Project EN070005: Southampton to London Pipeline Project
Interested Party: Nick Jarman, reference: 20022545

Attached is the Deadline 5 submission on behalf of the Neighbours and Users of Queen Elizabeth Park. This contains comments on responses to the ExA's Further Written Questions and comments on responses submitted for Deadline 4.

Deadline 5 Submission on Behalf of the Neighbours and Users of Queen Elizabeth Park

S2700-T284-C2 – Tree number and category

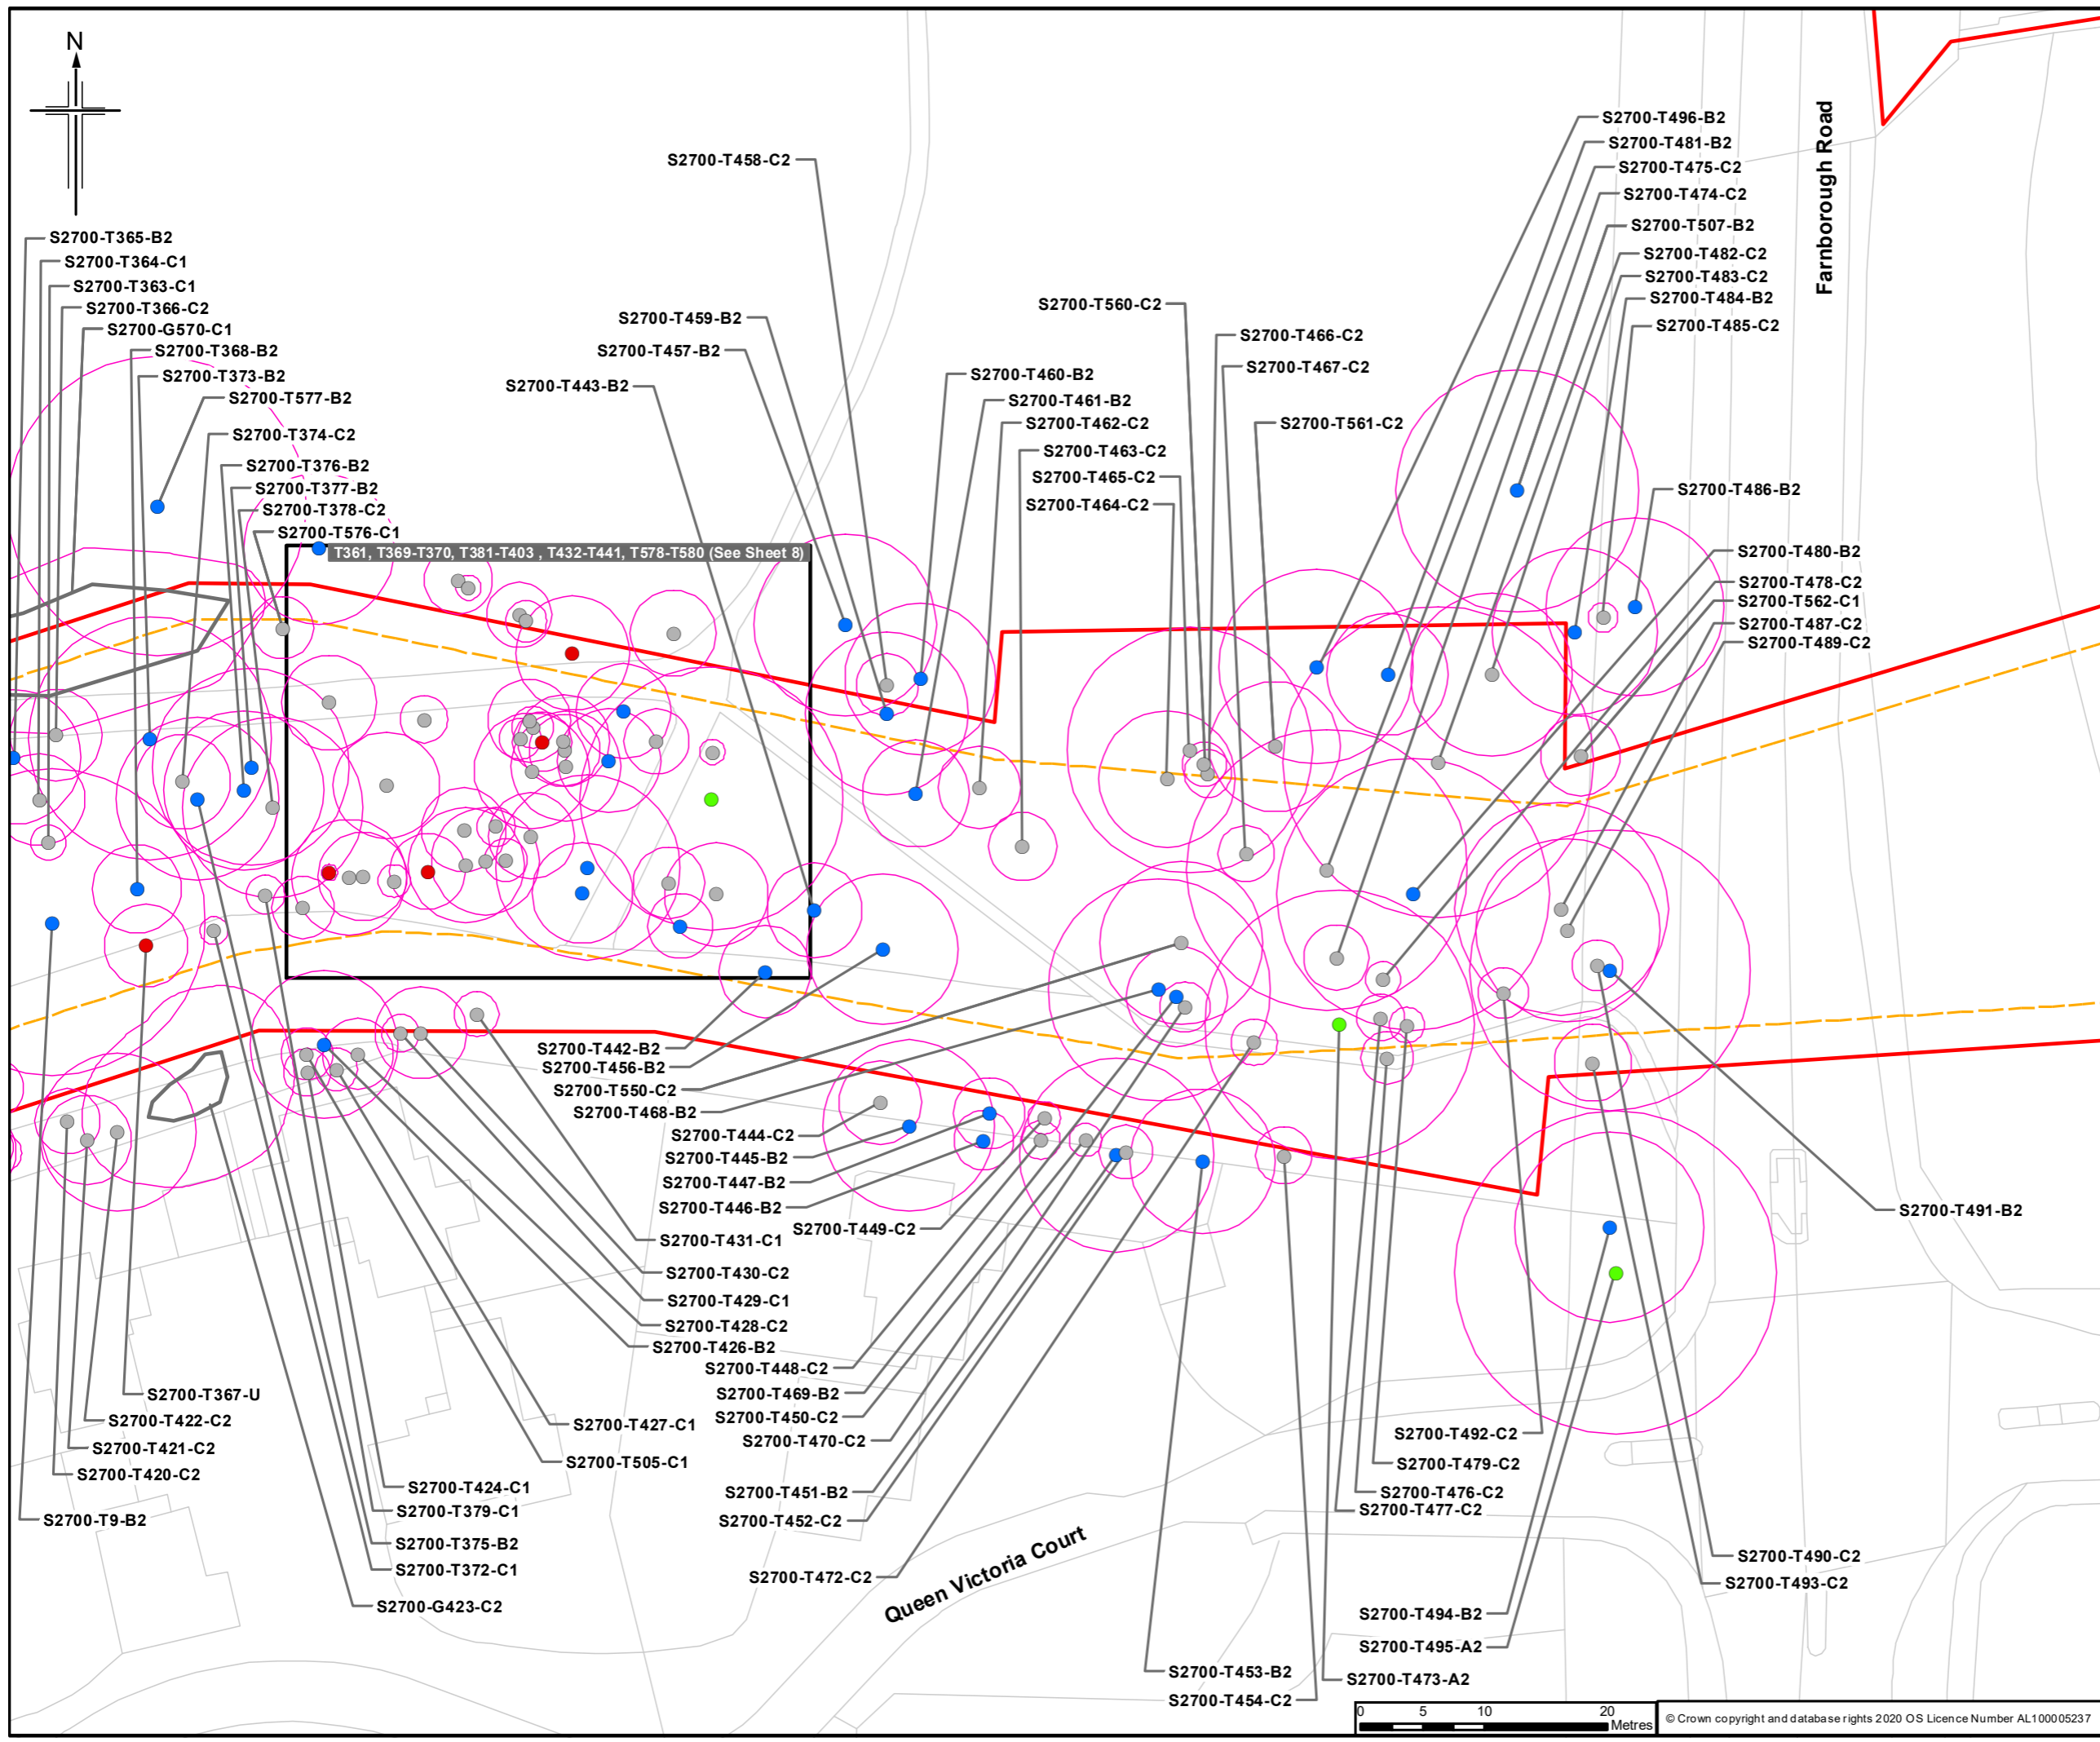
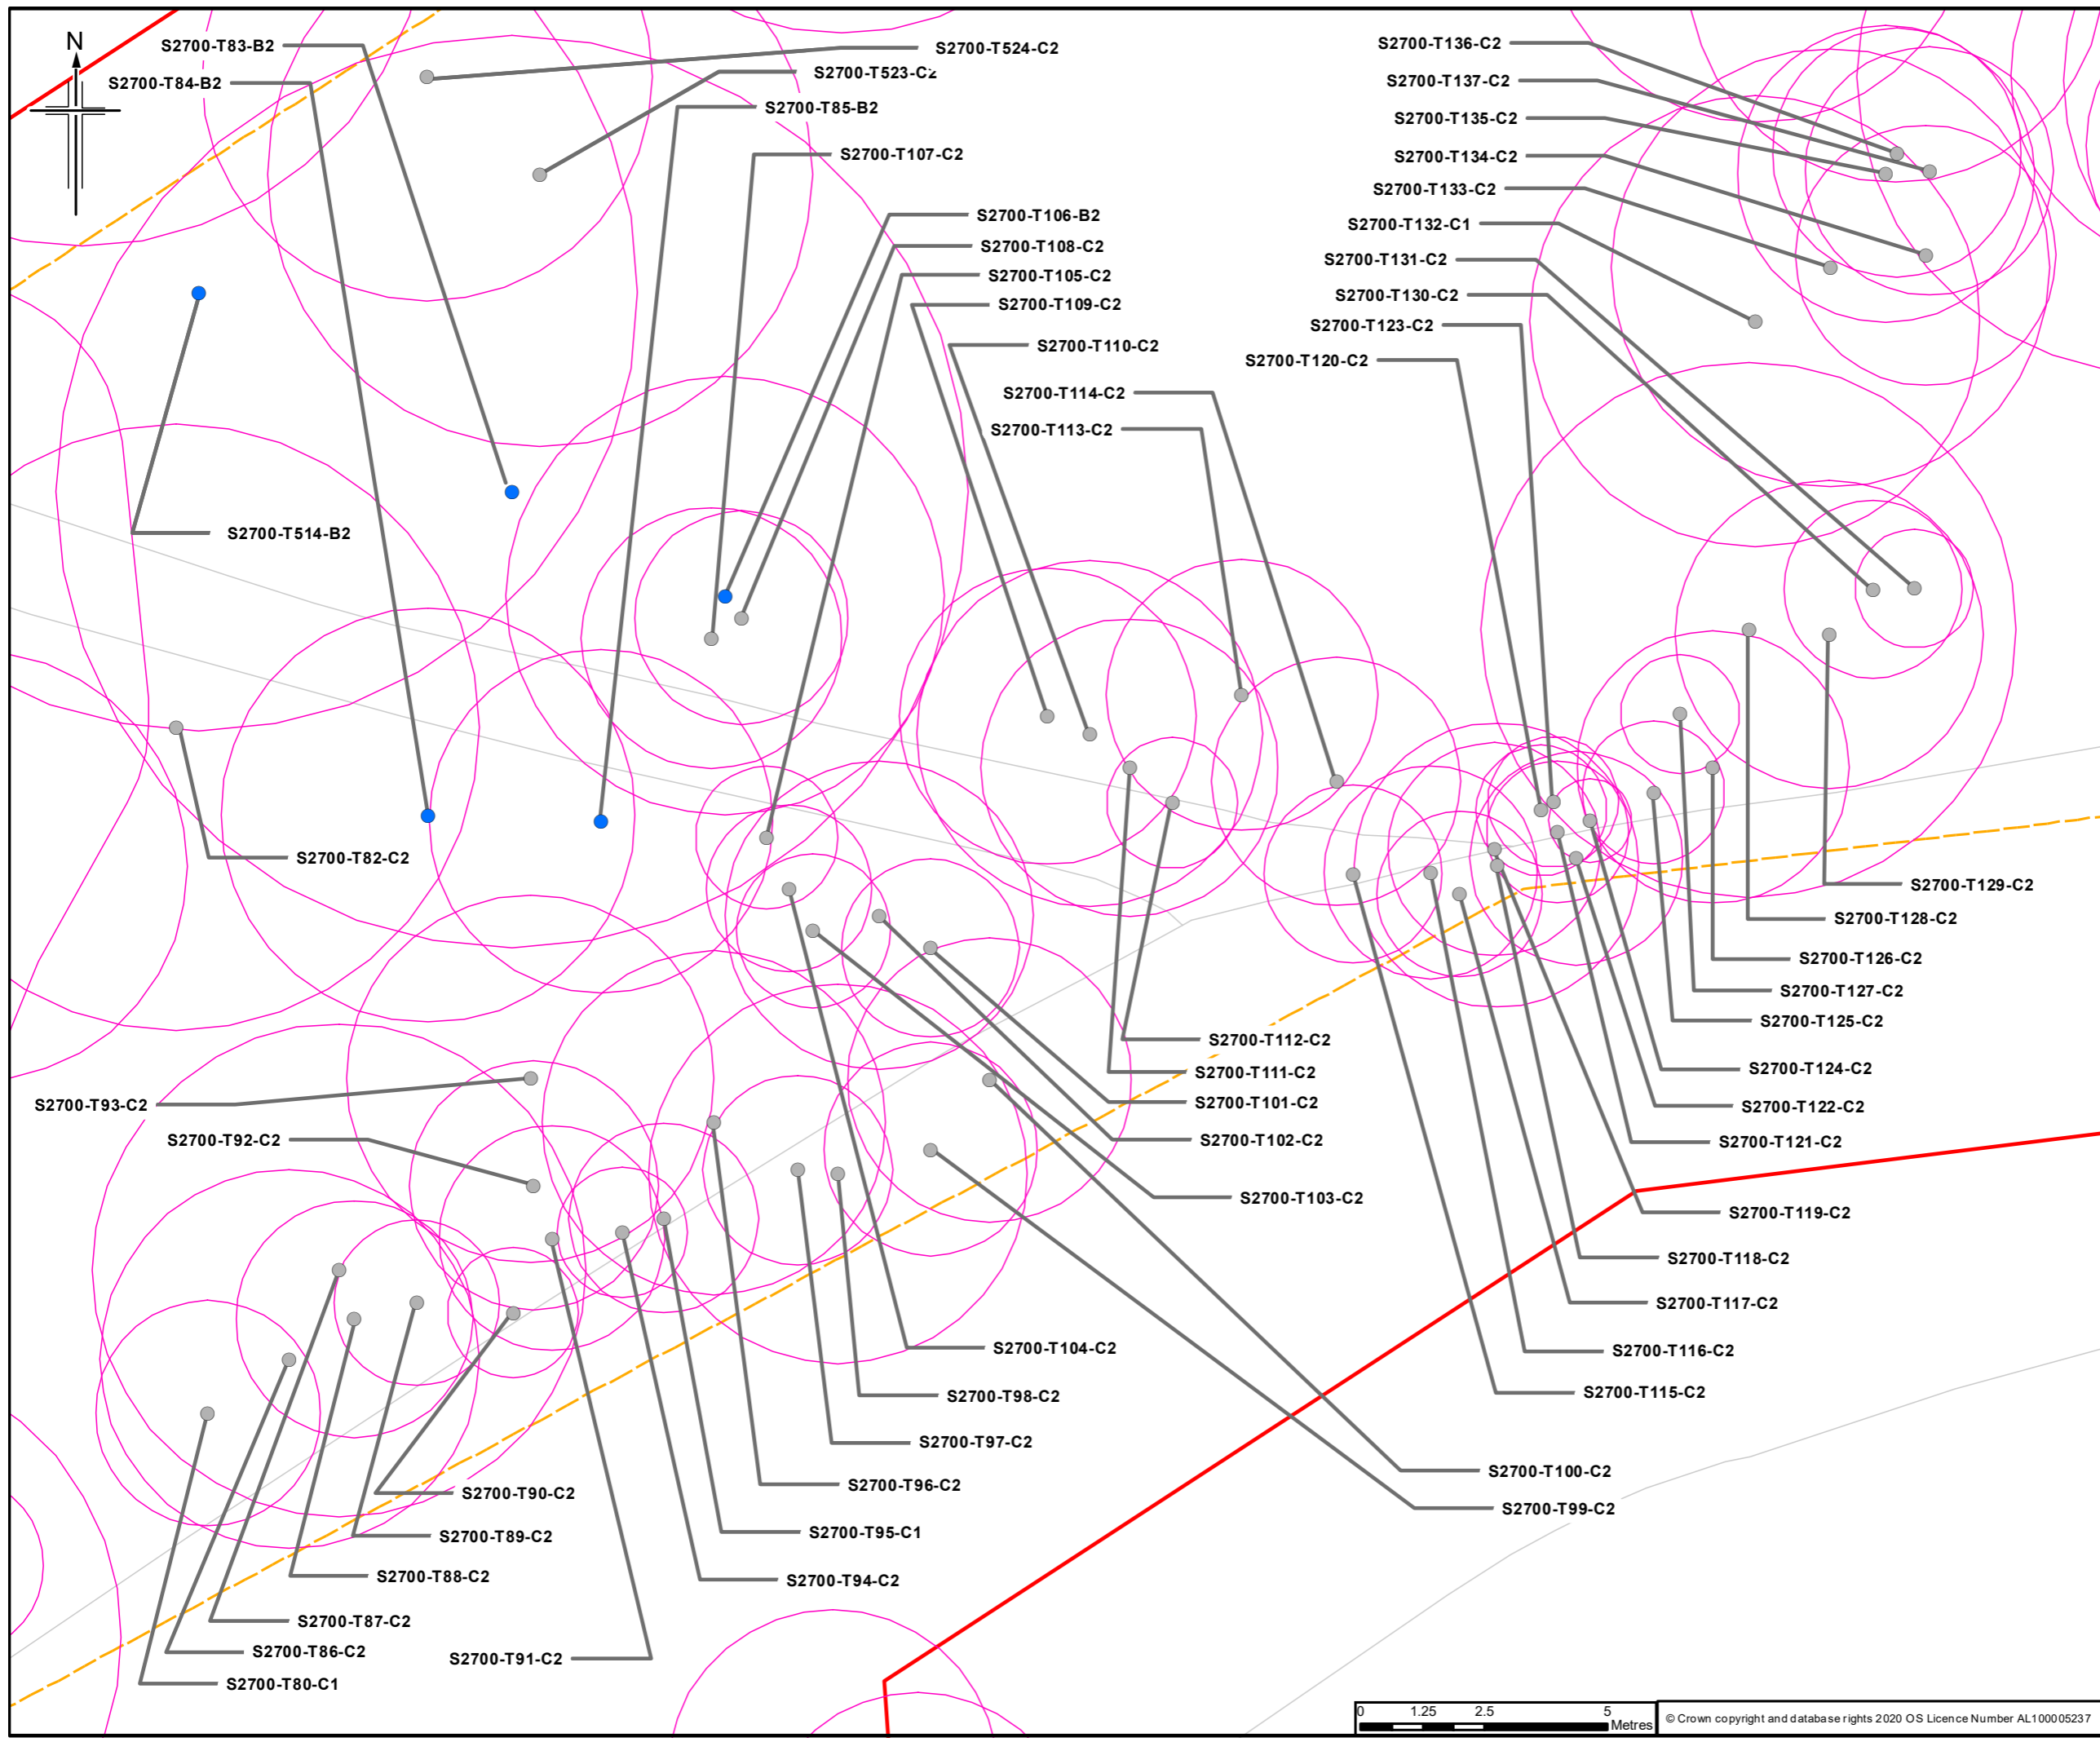
The tree survey lists over 580 trees (including groups), almost all of which are within the Order Limits. Although the survey is very comprehensive and mostly accurate, Esso omitted to identify which trees were classified as Notable or Veteran in the Woodland Trust's Ancient Tree Inventory (ATI). In the absence of this information, we have completed the work to map the Notable and Veteran Trees on the survey.

We have produced annotated versions of sheets 1-5 of the Queen Elizabeth Park Arboricultural Survey drawings, showing all trees listed in the ATI. These can be found in Appendix B. Extracts from these drawings are also used to illustrate specific points in the sections which follow.

Whilst we have not checked every single tree in the survey, we noticed a number of minor inaccuracies whilst we were correlating the survey with the ATI:

1. Path position near T432 and T433 - these trees are on the other side of the path.
2. T249 is listed as a sweet chestnut but is actually an oak.
3. A Notable Tree within the proposed Cabrol Road construction compound has been omitted.

We estimate that the total length of trench in the park is 532 metres, of which 472 is in narrow working area NW17. This is the length required to connect the TC018 pit to the proposed auger boring pit for TC019. 197 metres of the proposed trench is in root protection areas of Notable and Veteran Trees. That is 37% of the entire trench length within the park.

The root protection areas of 12 Notable Trees and 2 Veteran Trees will be violated by trench digging for the pipeline route as proposed. This will cause damage to the root systems and in many cases it is highly likely to kill the tree. BS5837:2012 states that:
